# CITY OF ALBUQUERQUE

November 29, 2021

**Re: McMahan Shopping Center**  
**10550 Unser Blvd NW**  
**Traffic Circulation Layout**  
Architect's Stamp 07-20-2021 (A11-D017)

UNSER & MCMAHON  
ENLARGED SITE PLAN  
ALBUQUERQUE, NM  
PROJECT #2063

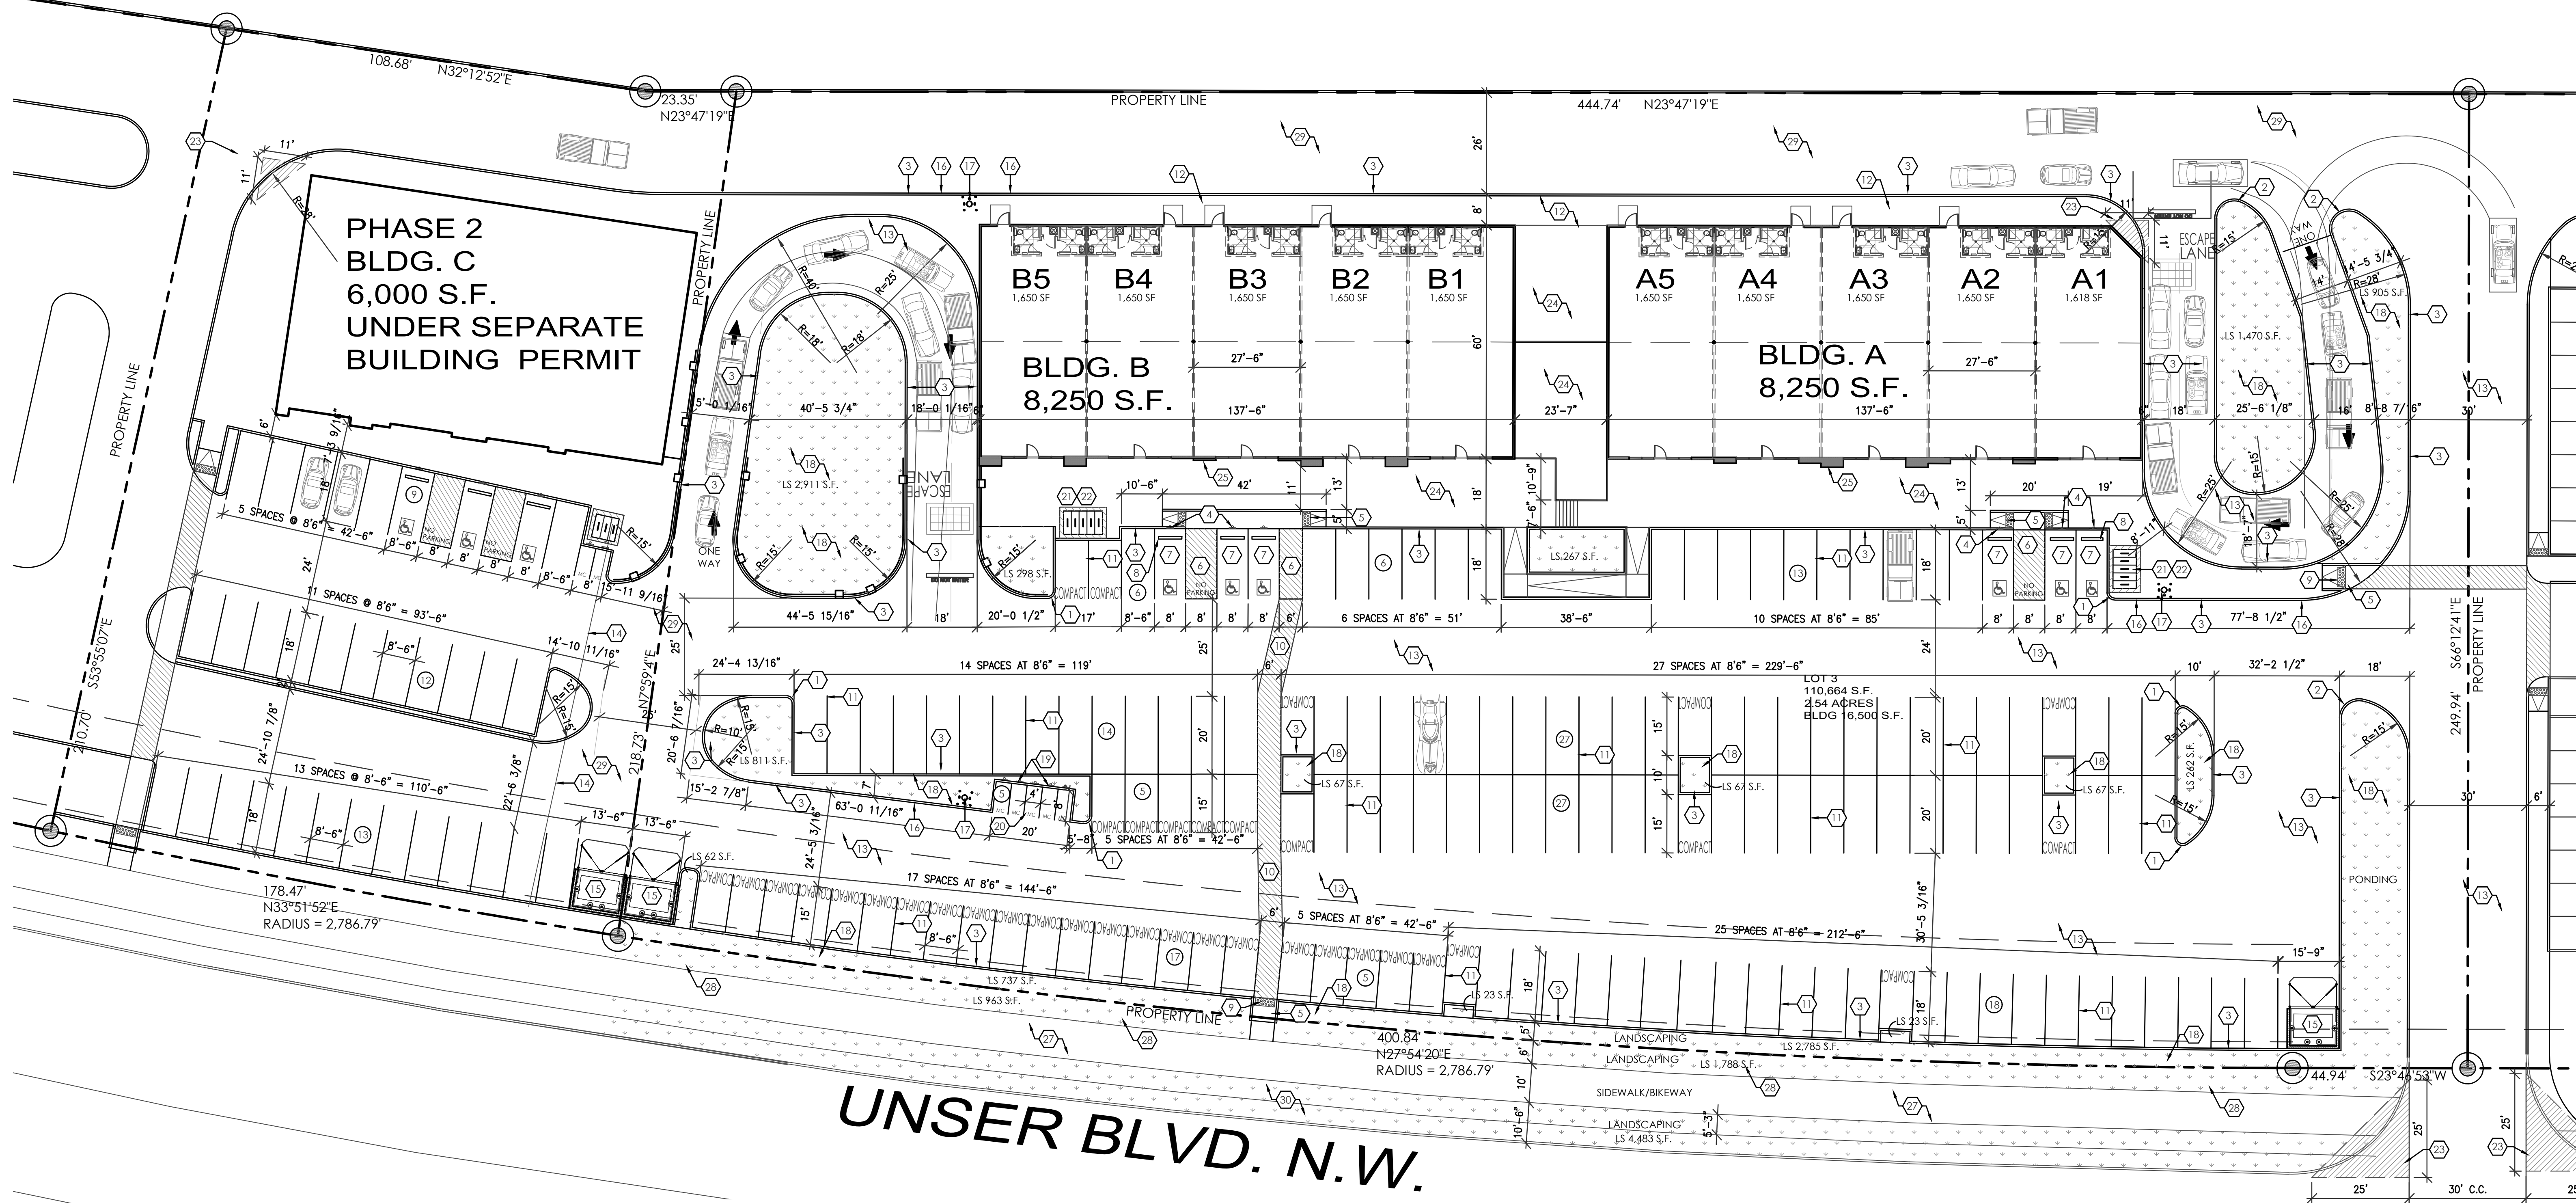
- The proposed 6 ft pedestrian pathway and ramps will need details/construction notes.
- Note to include details for curbing, striping and sidewalk limits.
- Provide keyed note 27 at Unser frontage trail.

- Provide keyed note 37 at drive thru entrance
- Bike Infrastructure location might interfere with 6 ft pedestrian pathway. Please provide width between keyed note 16 and drive thru to determine if the pathway is reduced/compromised.

- Keyed Note 4: the placement of signage will reduced the required 6 ft ADA pathway. Please address.
6. AS2.0:
- Detail A4: Pathway must be 6ft width inside to inside curb and ramp label 12:1 max.
  - Detail A6:
    - 1. Ramp must be 12:1 max.(label).
    - 2. Landing: 6'x'6 with 50:1 max.(label)
7. AS-2.1:
- Ramp slope 12:1 max call out.
  - Landing (6'x6') slope 50:1 call out.
  - Proposed 6ft width pathway must be inside to inside curb 6 ft in width.
8. Unser Proposed median work and deceleration and Bandelier roadway improvements:
- **APPROVAL OF FINAL CO (A condition for CO) that work order for these roadway improvements be completed, and accepted by the COA.**
9. Please provide a letter of response for all comments given.
